An
Coimisiún
Pleanála

Inspector's Report ACP322821-25

Question	Whether an extension to the rear of a dwelling is or is not exempted development.
Location	8 Clonmore, Kilteragh, Dooradoyle, Limerick.
Declaration	
Planning Authority	Limerick City and County Council.
Planning Authority Reference.	EC/107/25
Applicant for Declaration	Mubin Merchant
Planning Authority Decision	Is not exempted development.
Referral	First Party
Referred by	Mubin Merchant
Owner Occupier	Mubin Merchant
Observer(s)	None.
Date of Site Inspection	4 th September 2024.
Inspector	Derek Daly.

FLOOR PLAN & SITE LAYOUT PLAN

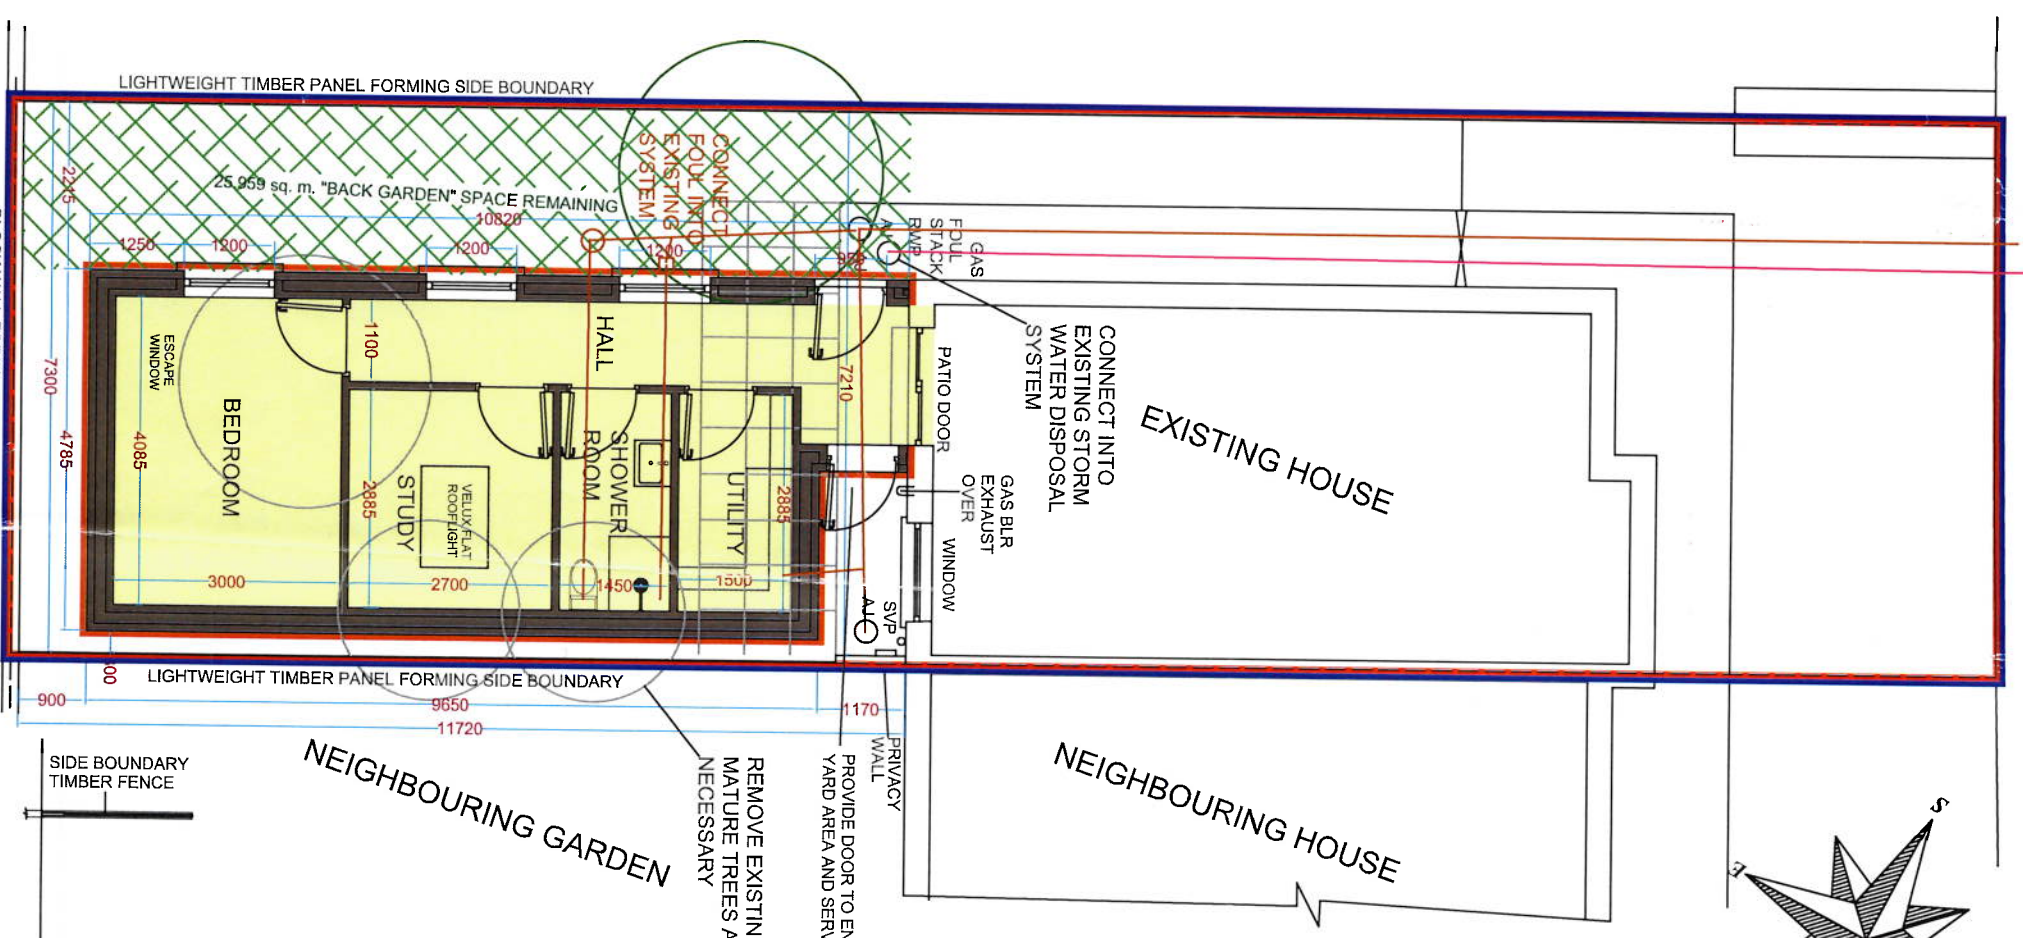
- 8.4.3. The proposal as indicated on the drawings and documentation will provide an area of private open space, reserved exclusively for the use of the occupants of the house, of in excess of 25 square metres.

- 8.4.4. Based on the documentation submitted the construction or erection of any such extension to the rear of the house does not reduce the area of private open space, reserved exclusively for the use of the occupants of the house, to the rear of the house to less than 25 square metres.

- 8.4.5. The wording of condition no.5 does not expressly state that the reserved 25 square metres of open space must be to the rear of the extension or an extended area of the dwelling and it can I consider be interpreted that reference to the rear of the house is based on the original and in this case current rear building line of the house, and that the present area of open space to be retained is greater than 25 square metres of open space. It is noted in this regard that in the inspector's report of RL2506 that the "rear of the house is confined to the area beyond the rear wall of the main house" which can be interpreted I consider to the original rear wall of the house
